Technical Memorandum

Project Number: 1908.0007

**Re: Response to City of Marysville Comments
Groundhog PRD, PA22-019**

DATE: 5/27/2022
 JOB: 1908.0007
 BY: DDS / MW
 SCALE: AS SHOWN
 SHEET: 2

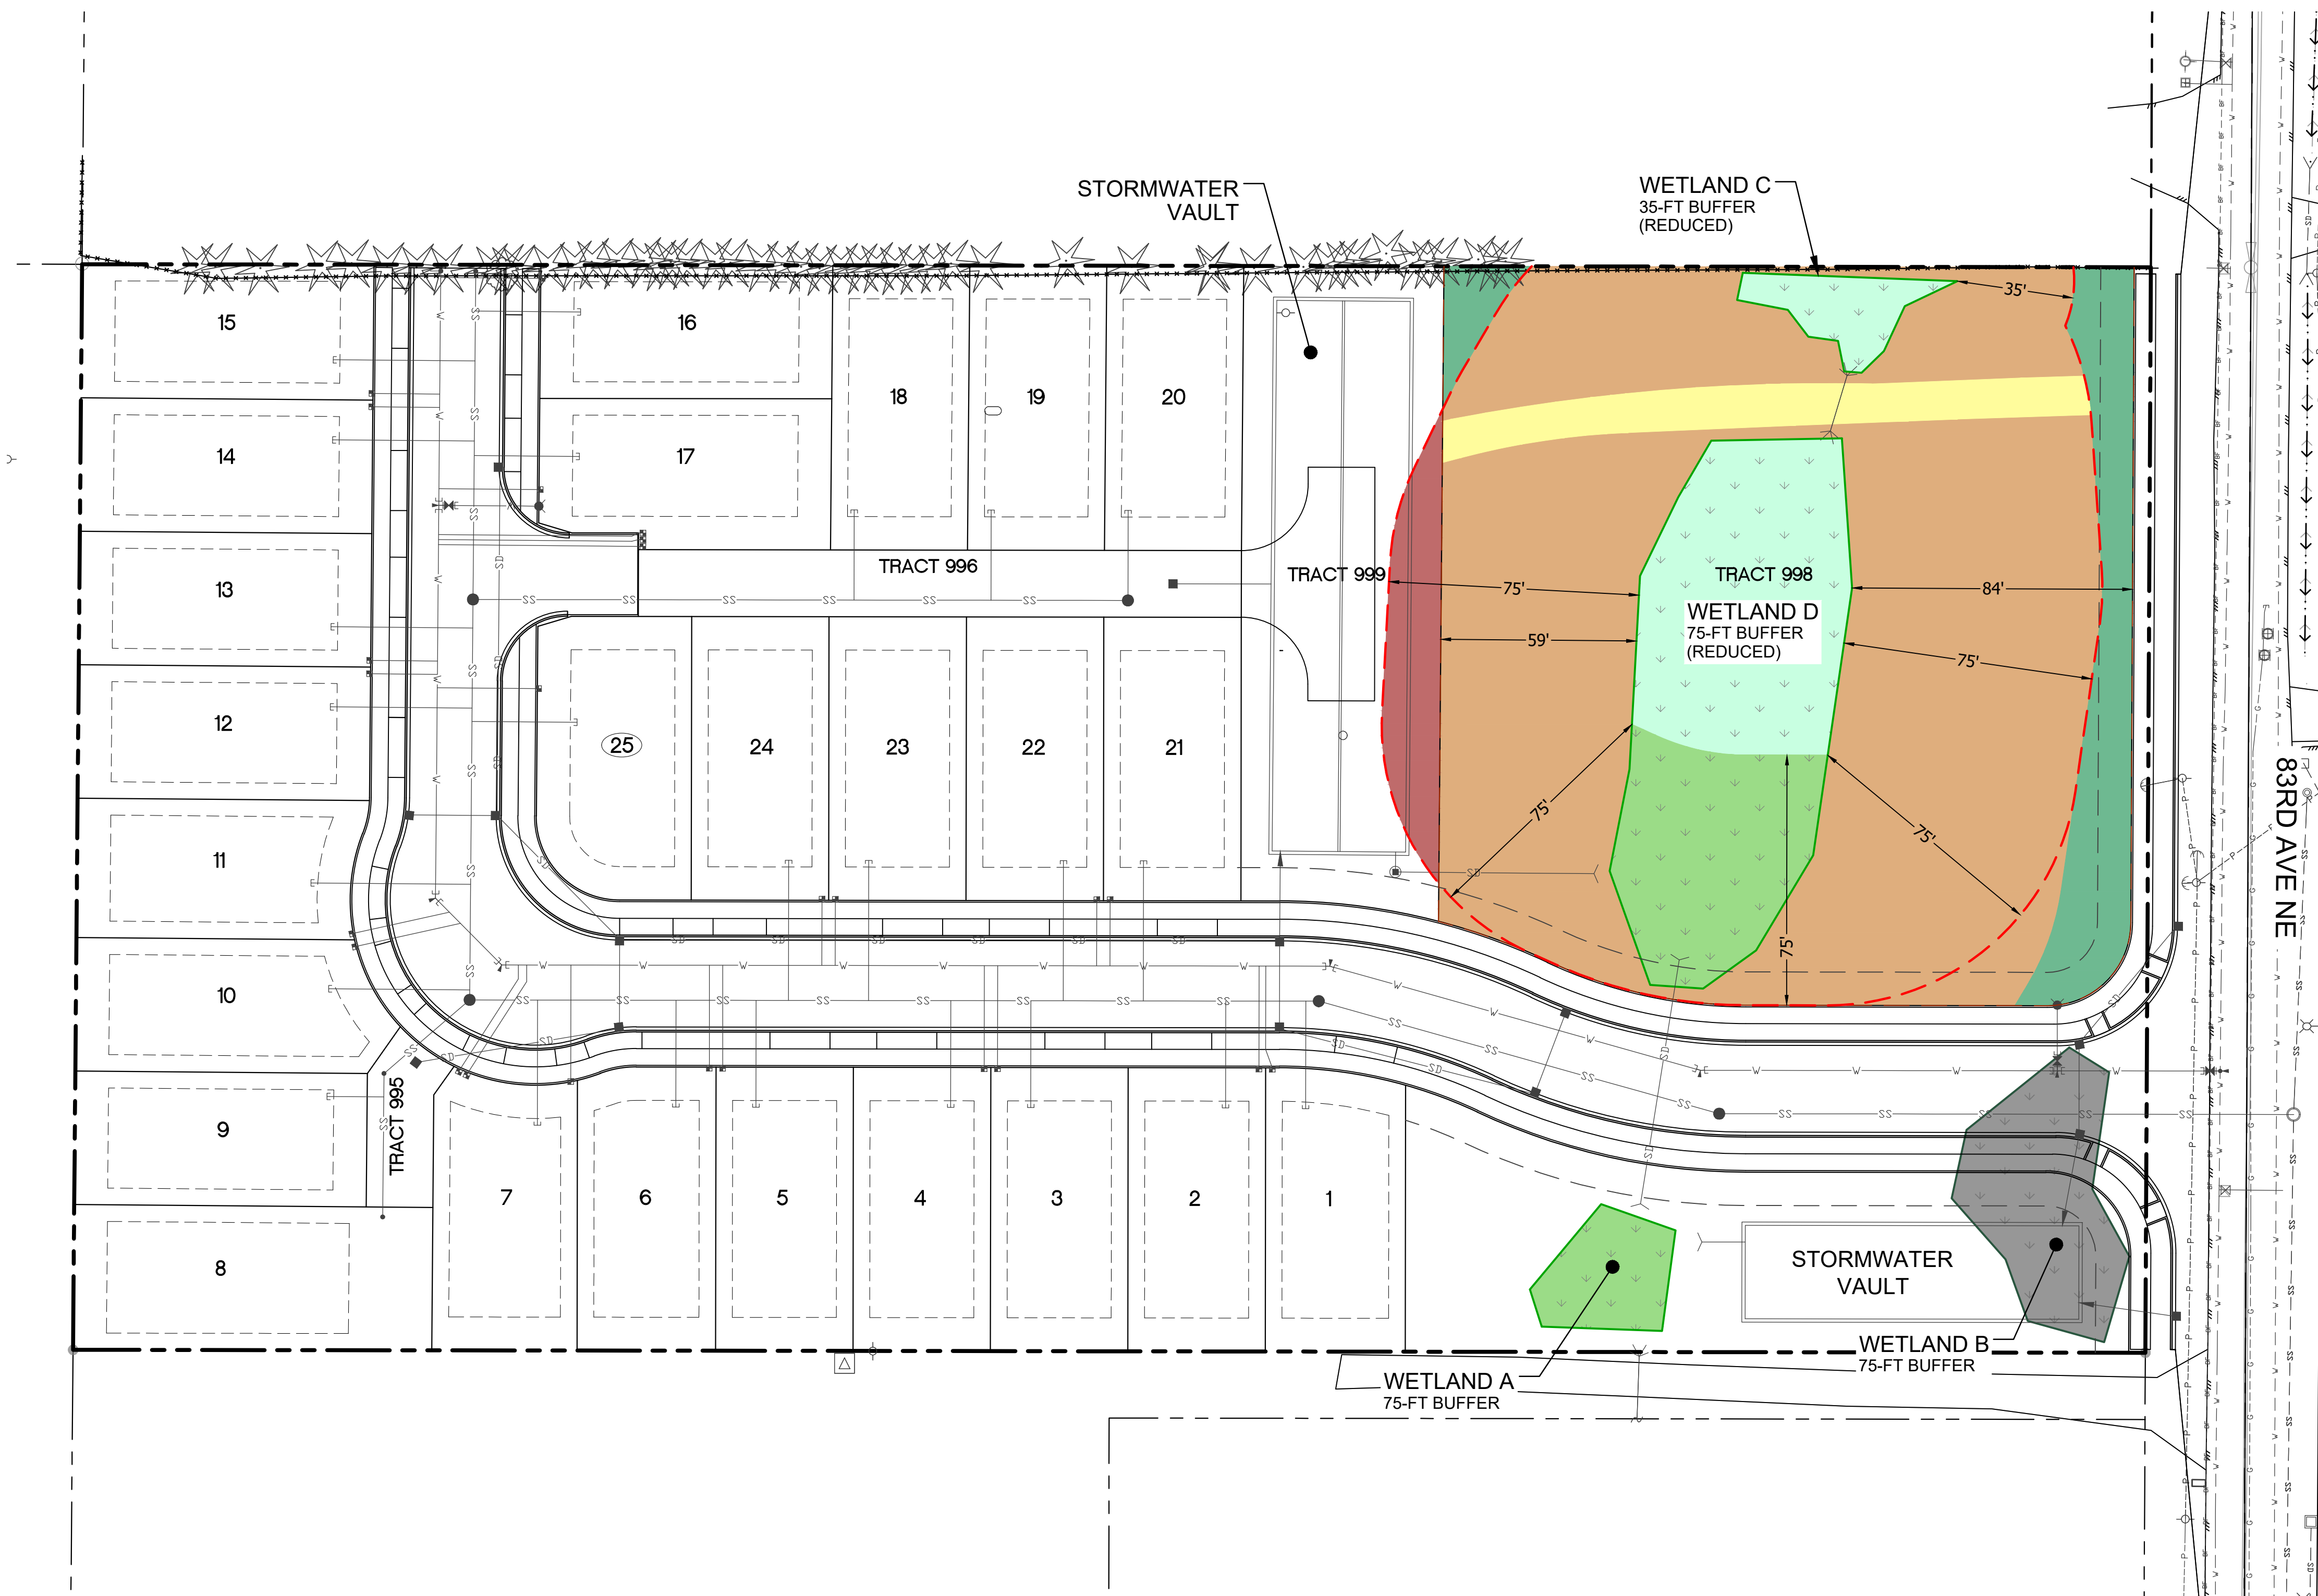
- 1) *Pursuant to MMC 22E.010.120(3)(c) for wetland mitigation ratios, Category III wetlands require mitigation of ratios of 2:1 for enhancement areas along with 1:1 for re-establishment or creation of buffers.*

Provide an addendum to the Conceptual Mitigation Plan that clarifies that these required ratios would be satisfied through onsite compensatory mitigation and off-site contribution to the SBMB.

Compensation for the direct and indirect wetland impacts will be provided through the purchase of mitigation bank credits from the Snohomish Basin Mitigation Bank (SBMB). Onsite mitigation actions are limited to non-compensatory buffer restoration/enhancement in accordance with MMC 22E.010.100(3). While wetlands proposed to be impacted are Category III wetlands, per MMC 22E.010.130(2), replacement ratios for wetland mitigation bank credits will be consistent with the Snohomish Basin Mitigation Bank Instrument document in accordance with US Army Corps of Engineer and the Environmental Protection Agencies final rule, which takes into account the wetland rating/category (Habitat Bank LLC, 2016).

In addition, indirect wetland impacts are compensated at half the standard ratio of direct impacts in accordance with agency guidance (WSDOE et al, 2021). Mitigation ratios outlined in MMC 22E.010.120(3)(c) apply to permittee-responsible compensatory mitigation, and onsite buffer restoration/enhancement is proposed in accordance with MMC 22E.010.100(3) as existing onsite buffers are degraded. As all proposed impacts are compensated for through the use of the SBMB and onsite buffer enhancement/restoration is a non-compensatory action, wetland mitigation ratios outlined in MMC 22E.010.120(3)(c) do not apply.
